**From:** [REDACTED]  
**To:** [Planning Comments \(Shared Mailbox\)](#)  
**Cc:** [REDACTED]  
**Subject:** Objection to Application Ref: 6/2023/2089/HOUSE - Freny Cottage 41 Northaw Road East Cuffley, EN6 4LU  
**Date:** 01 November 2023 09:37:01  
**Importance:** High

**Re: Second Application. Reference: 6/2023/2089/HOUSE  
Proposed Development at: Freny Cottage 41 Northaw Road East, Cuffley, Potters Bar EN6 4LU (the "Application")**

Proposal proposed layouts and elevations

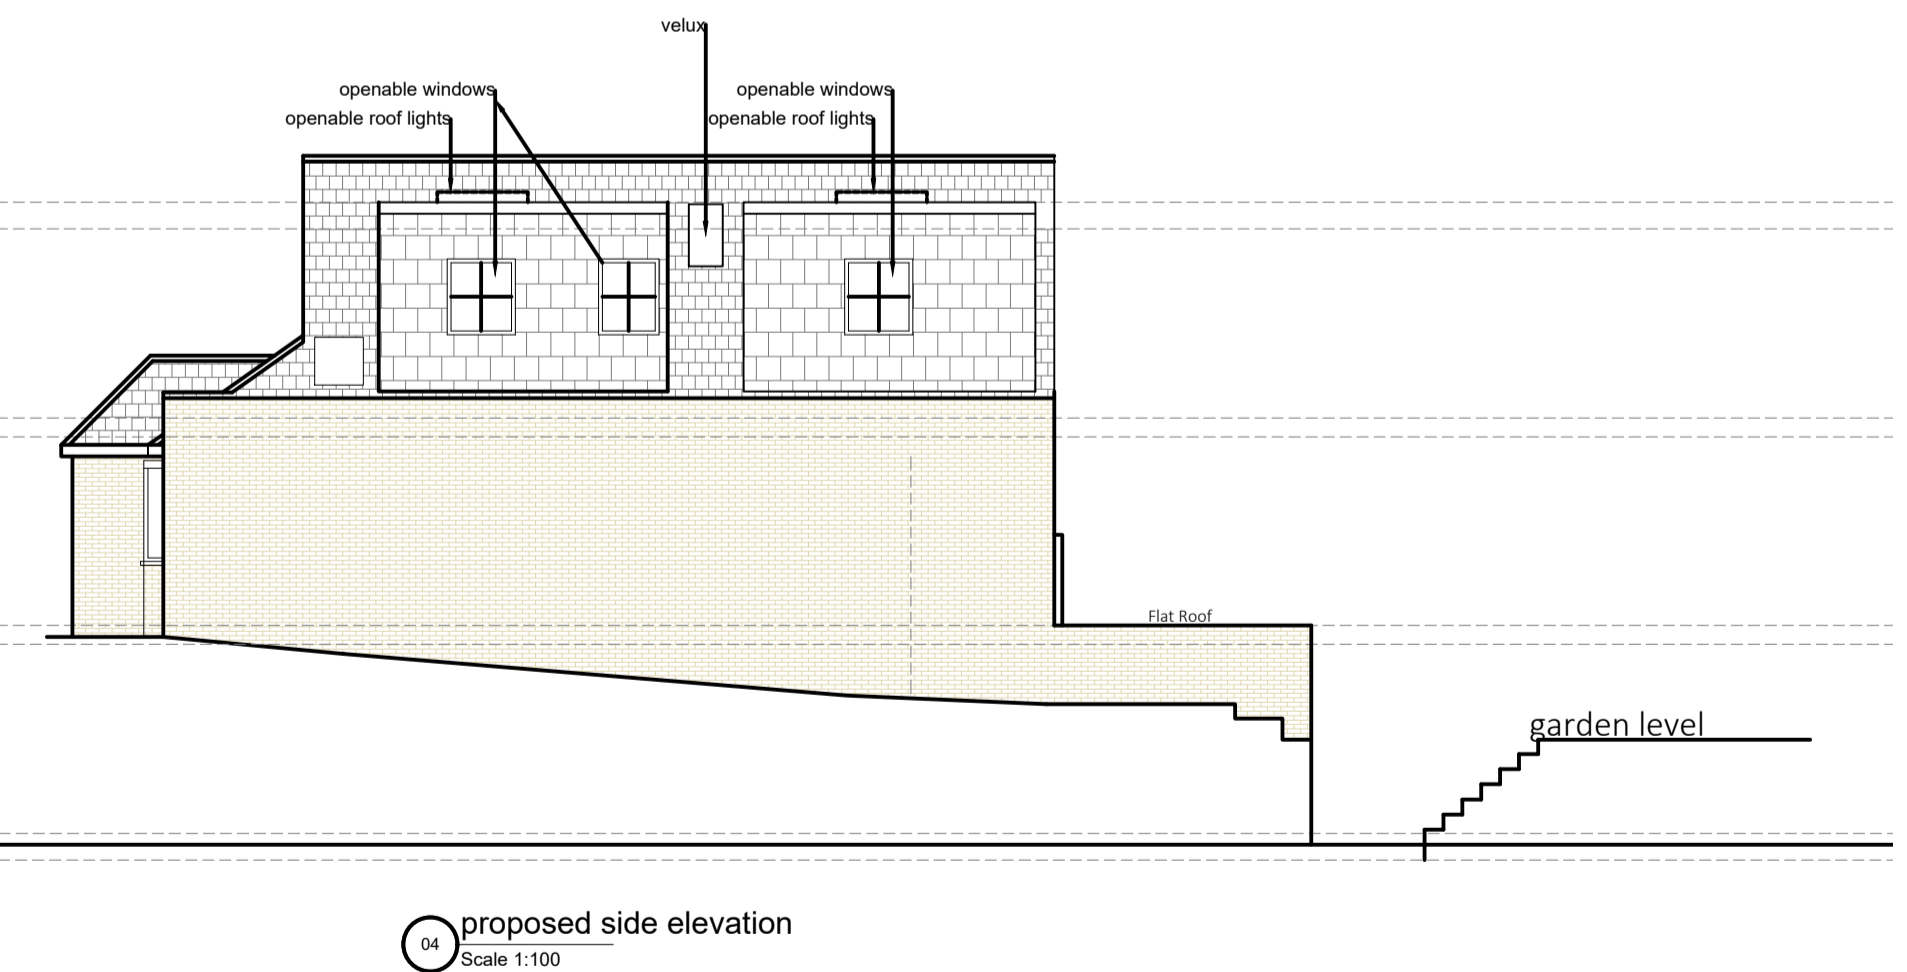
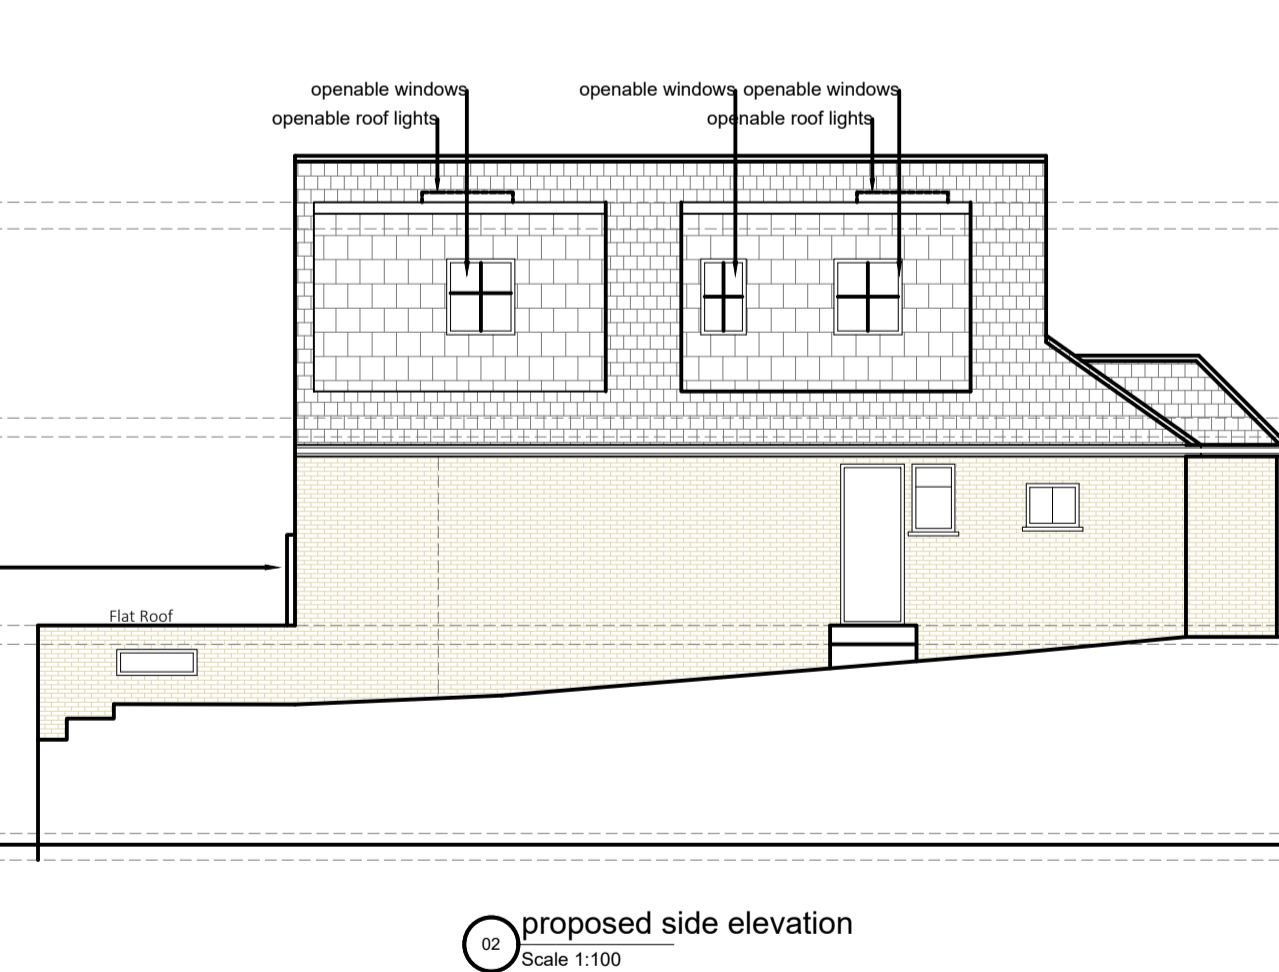
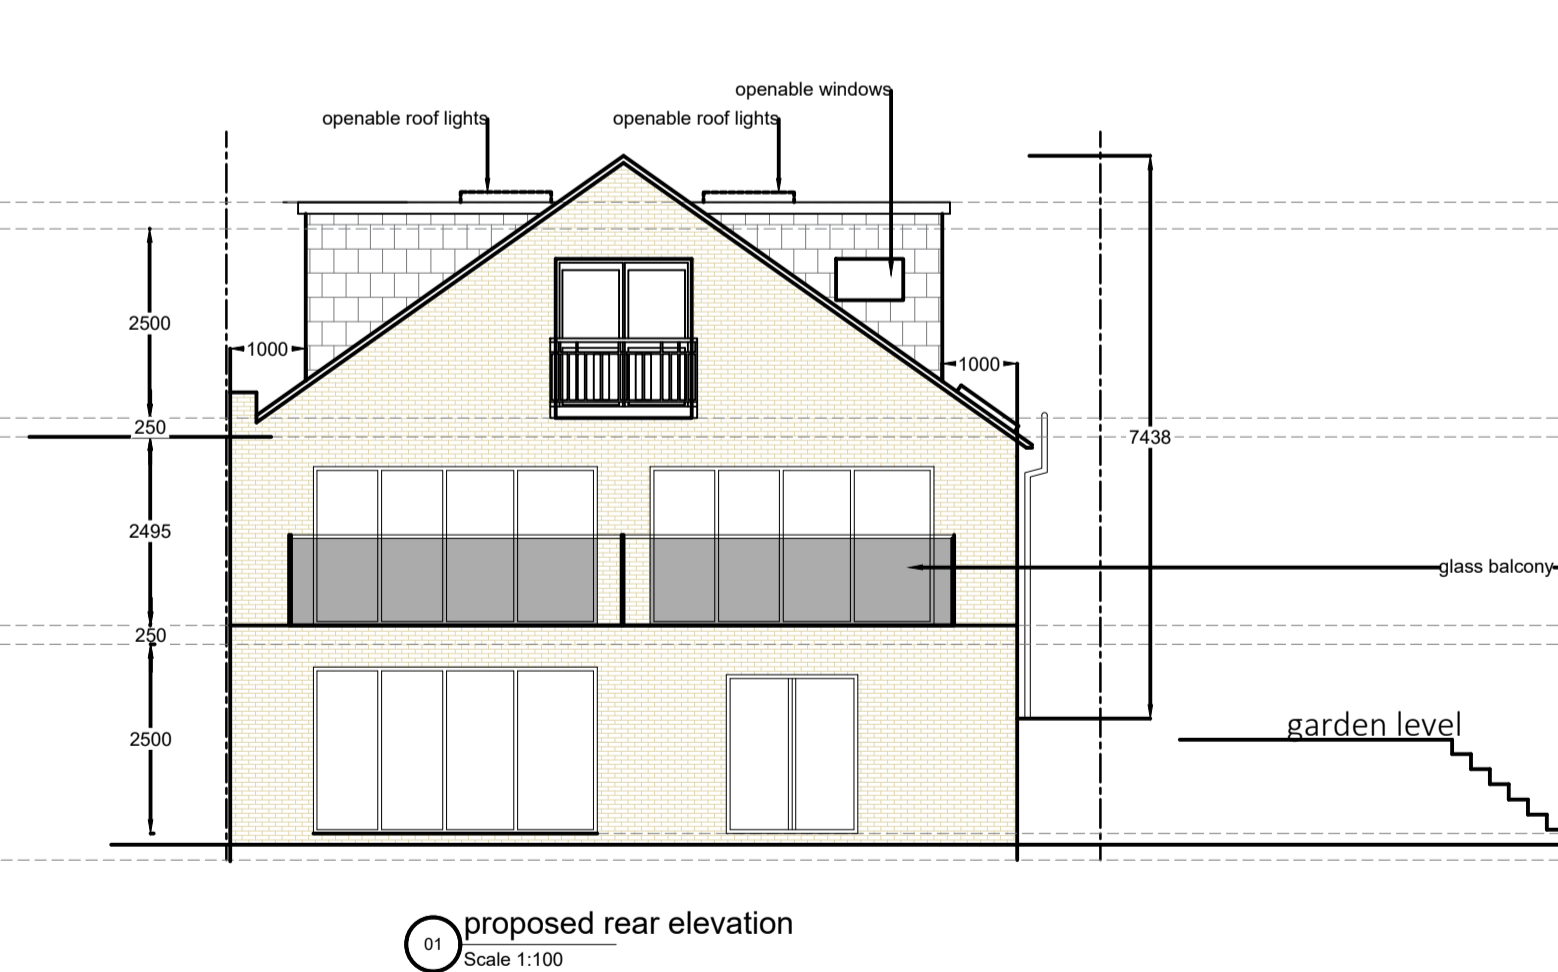
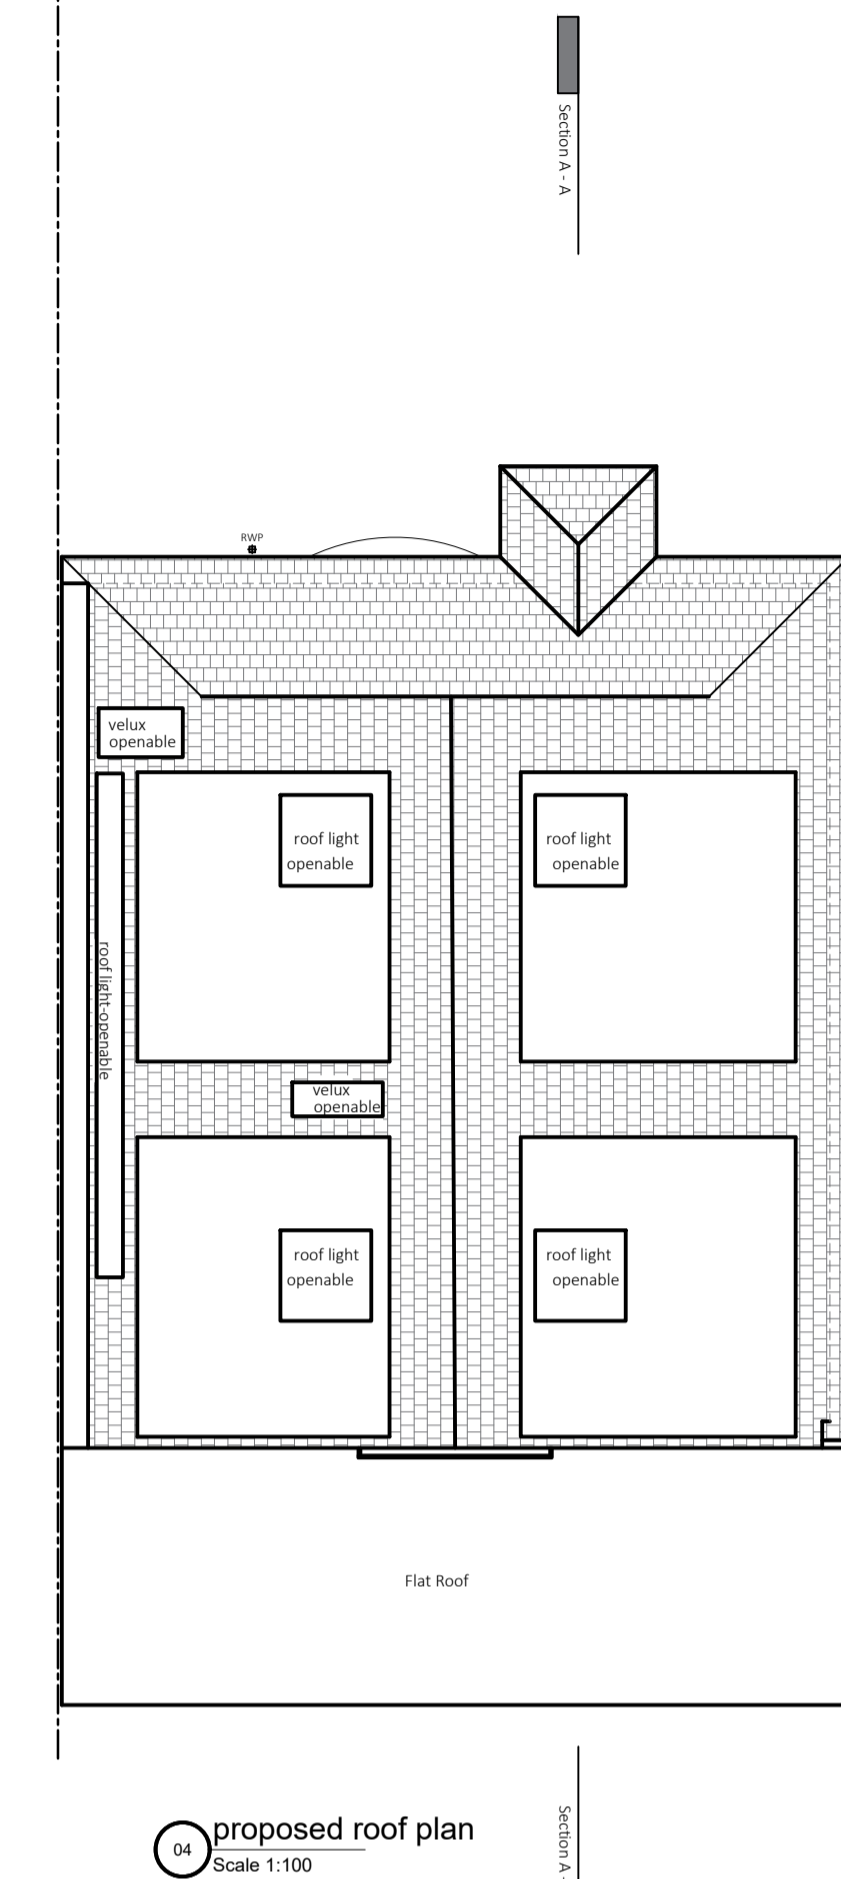
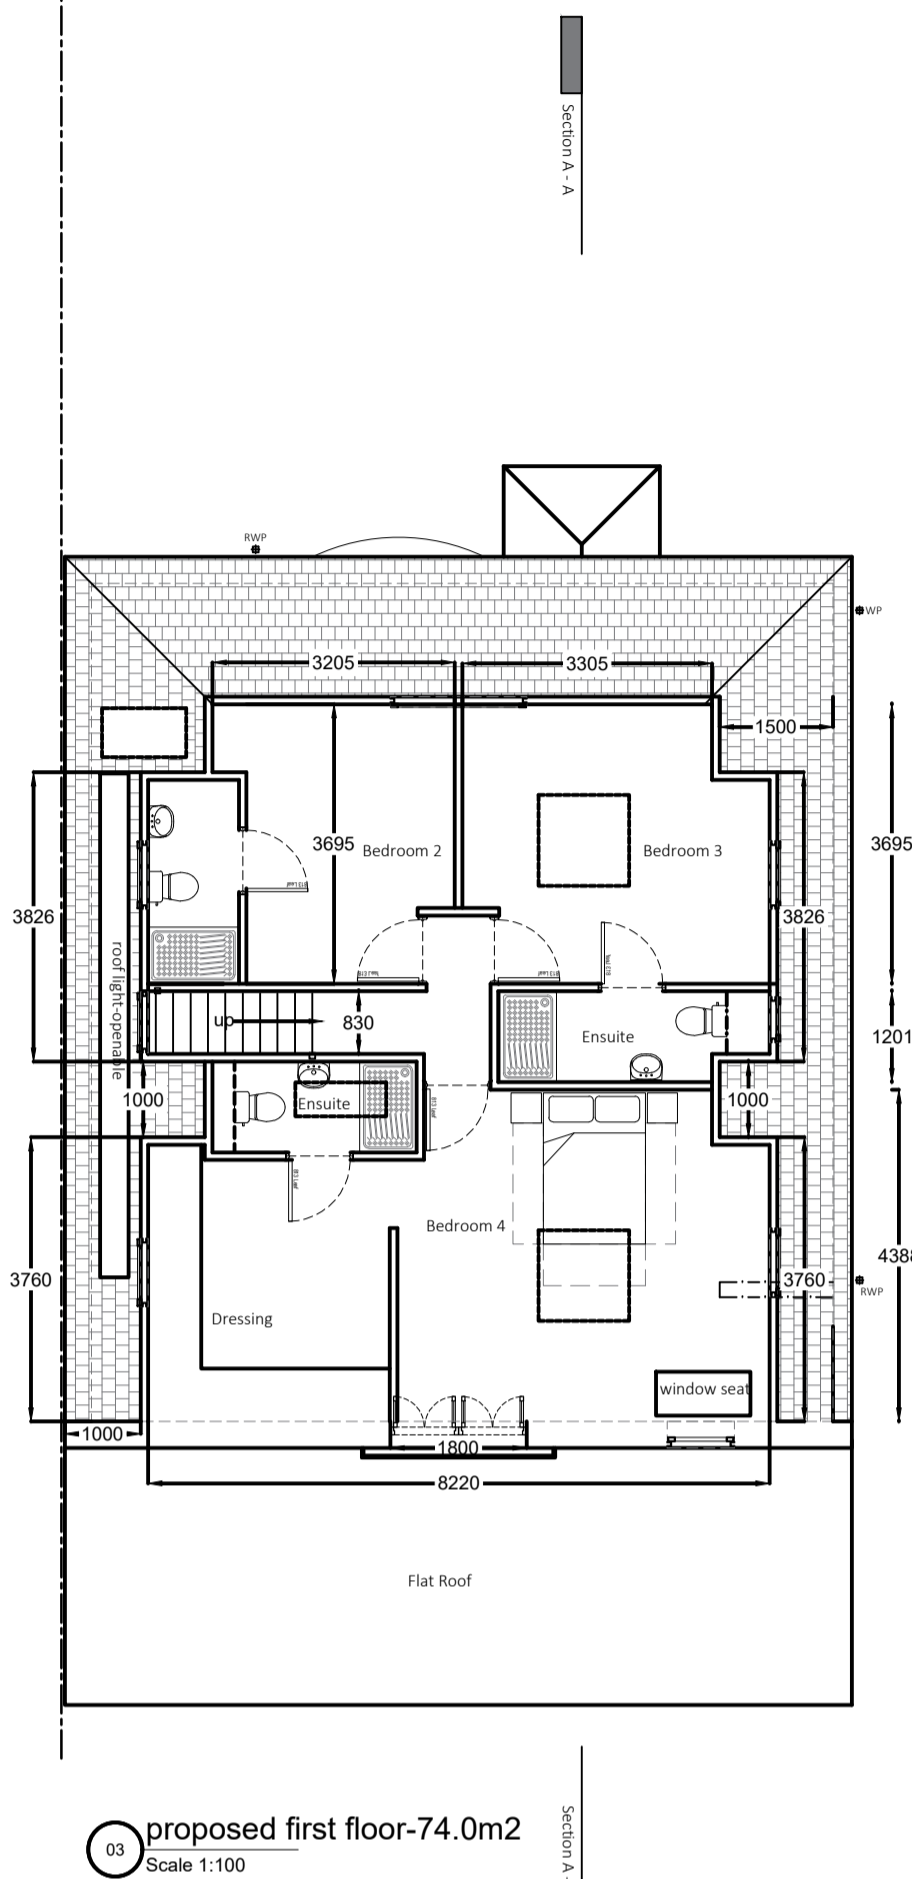
- A. The additional ridge height will render this building a sore thumb, and it will not

blend with neighbouring properties.

- B. **Privacy.** The additional height will allow dormer windows to look down into neighbouring properties.

Our right to light will be lost if the roof is allowed to be extended to near the boundary with No.43.

It appears that the 45 degree of the Cuffley Neighbourhood Plan D1( c ) (see No.6 below), has been contravened. This will result in loss of light to our principal bedroom, as well as other habitable rooms.

The dormers facing No.43 will be very close to the boundary line. Further, they have openable and unobscured windows. This contravenes D1 ( b ) of the Cuffley Neighbourhood Plan.

Further, the lack of detail in the drawing makes it difficult to understand from the Application how the adjoining properties will be protected from overlooking, loss of privacy and also the potential loss of light.

The Application contains side elevation glazing, which overlooks adjacent properties. This glazing is avoidable. No glazing should be allowed. The Application contravenes D1 ( b ).

We believe that the expansion of the roof over the side extension to the boundary with No.43 as well as the additional ridge height, both result in increased overshadowing and would significantly reduce the light to our main bedroom in contravention of D1 ( c ).

The 5.2metre ground floor extension, will be built on the boundary line with No.43 and require multiple mature hedges and to be removed to accommodate.

One of the many grey areas of the Application is the creation of a roof terrace. The single storey extension lines up with openable windows, in front of which there is currently a balcony. The flat roof area must not be able to be used as a balcony, as this would result in a significant loss of privacy and overshadowing.

The Application seems to request a new party wall astride the property boundary. We do not agree to this. Nor do we agree to any foundations being built astride the boundary or on our property at No.43. The current Party Walls are in good order.
